Ribble Valley Borough Council
Church Walk,
Clitheroe,
BB7 2RA

Phone: 0300 123 6780
Email: lhscustomerservice@lancashire.gov.uk
Your ref:
Our ref: LHS/CS/3/2016/0348
Date: 19th May 2016

Proposal:	Proposed alterations to existing vehicular access
Location:	Clitheroe Cricket Club Chatburn Road Clitheroe BB7 2AW
Grid Ref:	374673 - 442436

DRG TITLE Proposed Site Plan

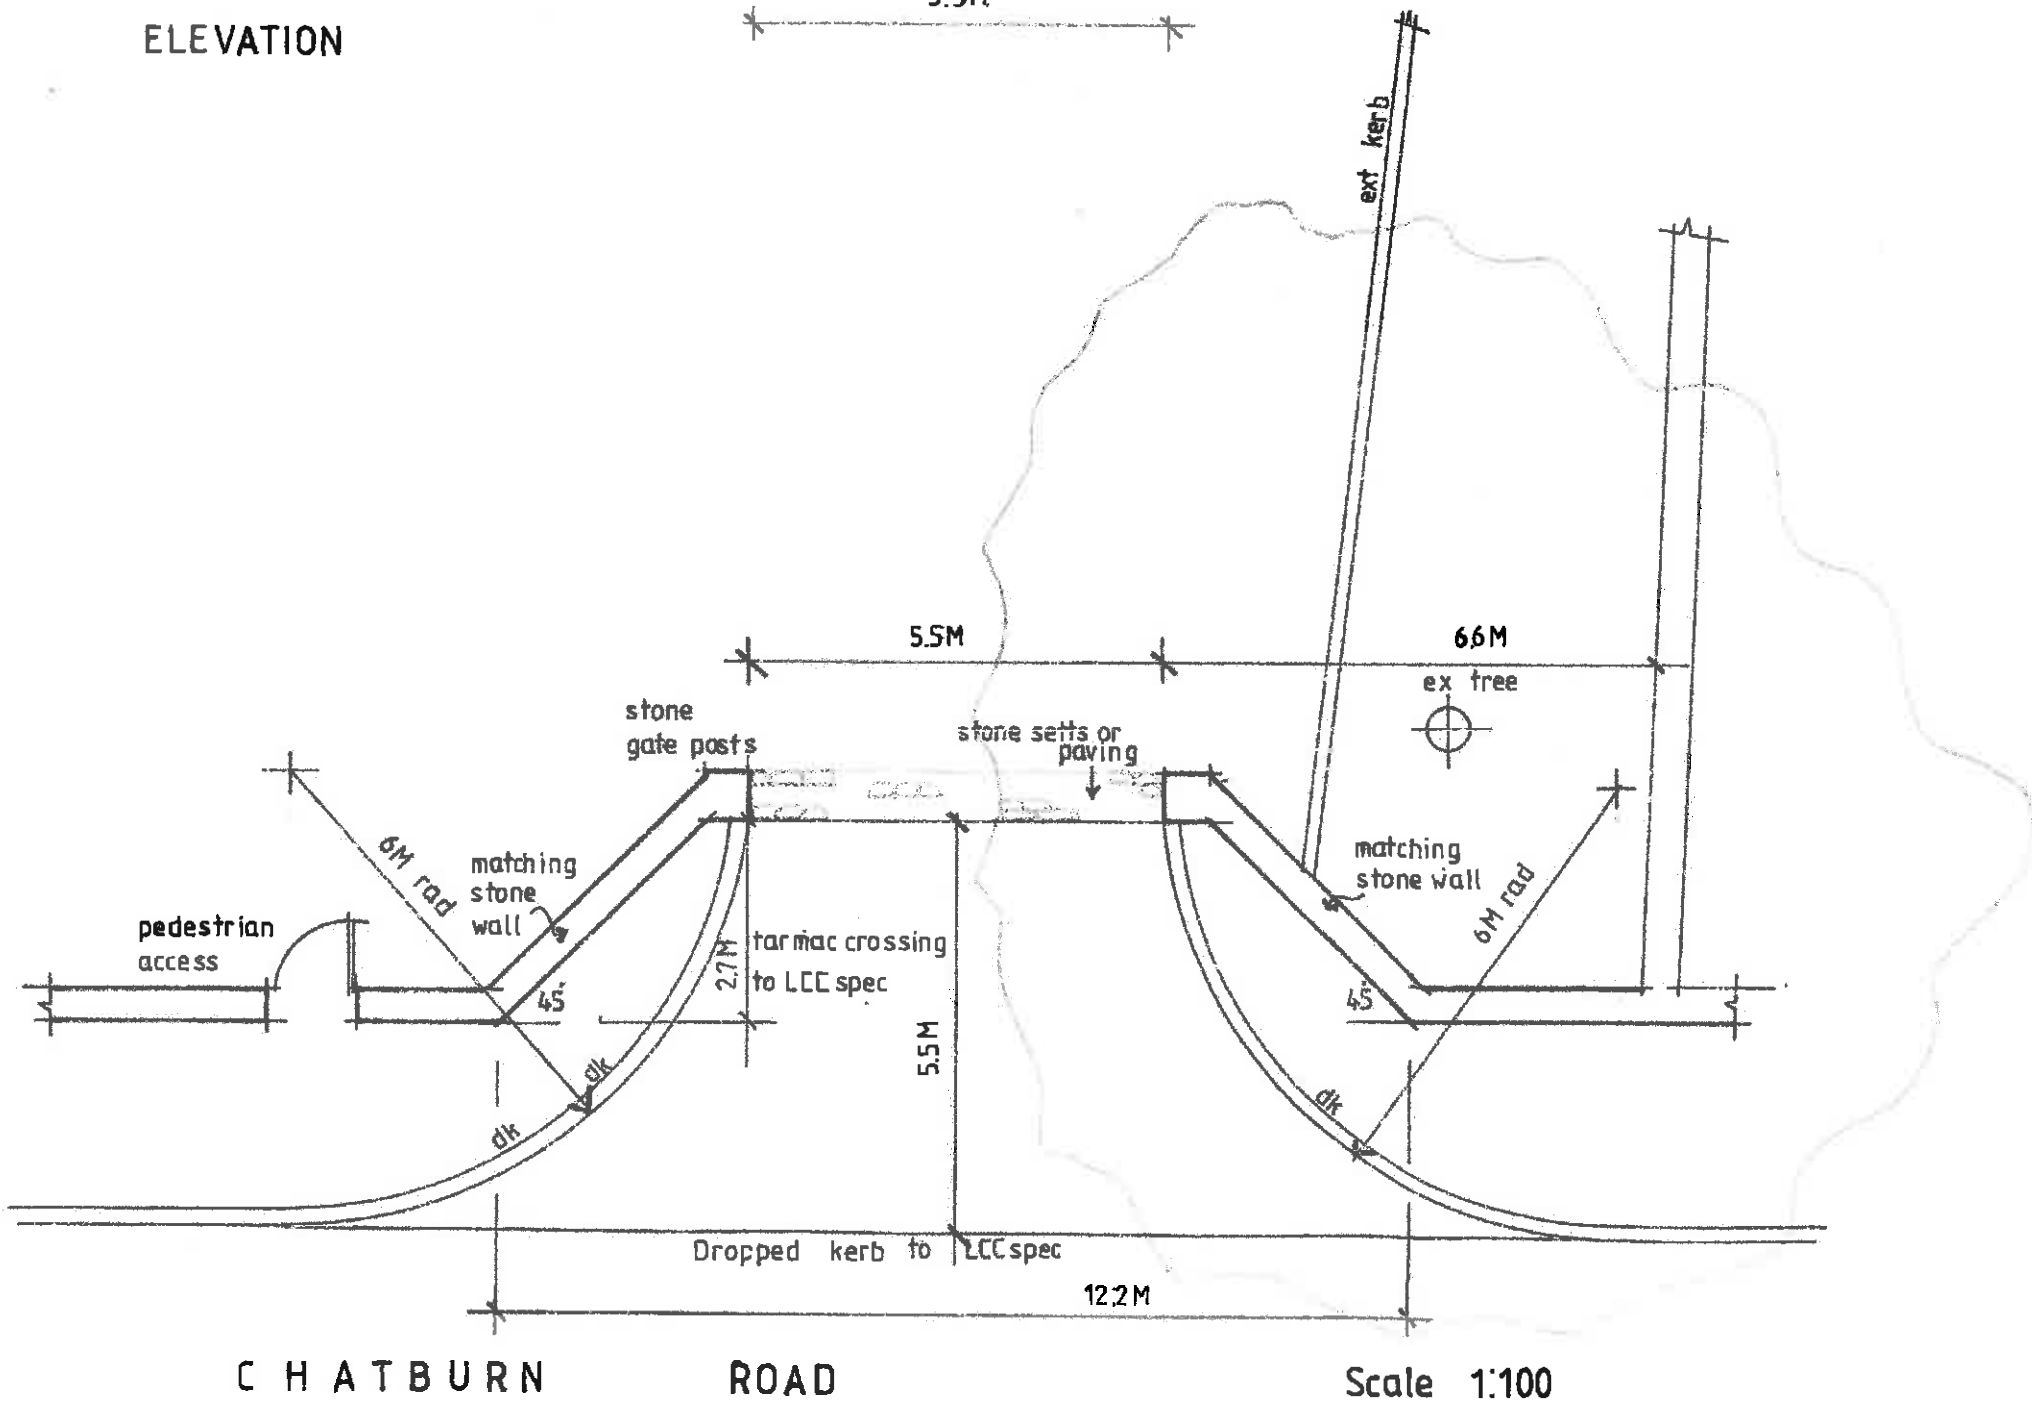
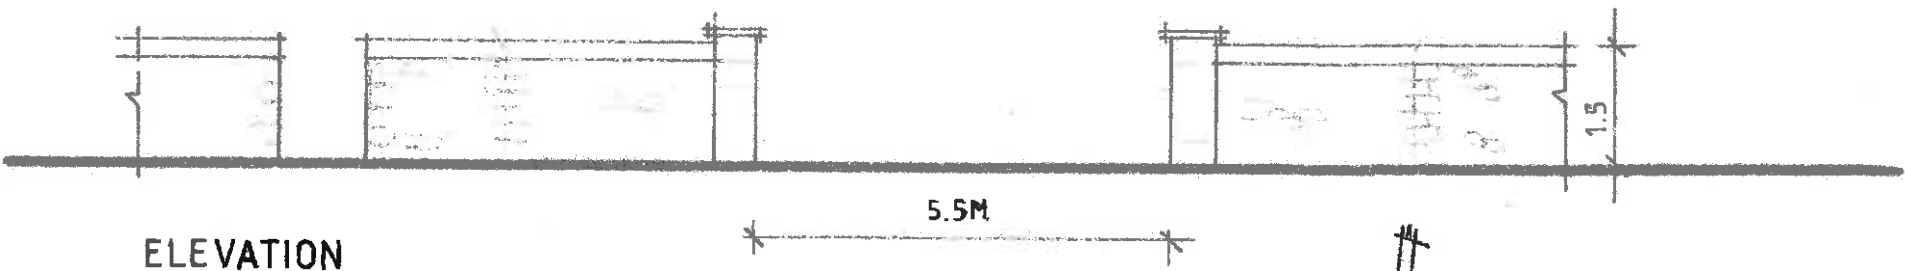
1. All gates and associated mechanisms to be located outside the adopted highway and the gates to have physical restraints to prevent the gates from opening onto the adopted highway. Reason to ensure the adopted highway is not obstructed by the gates or are a hazard to other road users.
2. All of the highway works within the adopted highway have been constructed in accordance with a scheme that shall be submitted to and approved by the Local Planning Authority in consultation with the Highway Authority as part of a section 278 agreement, under the Highways Act 1980. Reasons: In order to satisfy the Local Planning Authority and Highway Authority that the final details of the highway scheme/works are acceptable before work commences on site and to enable all construction traffic to enter and leave the premises in a safe manner without causing a hazard to other road users.
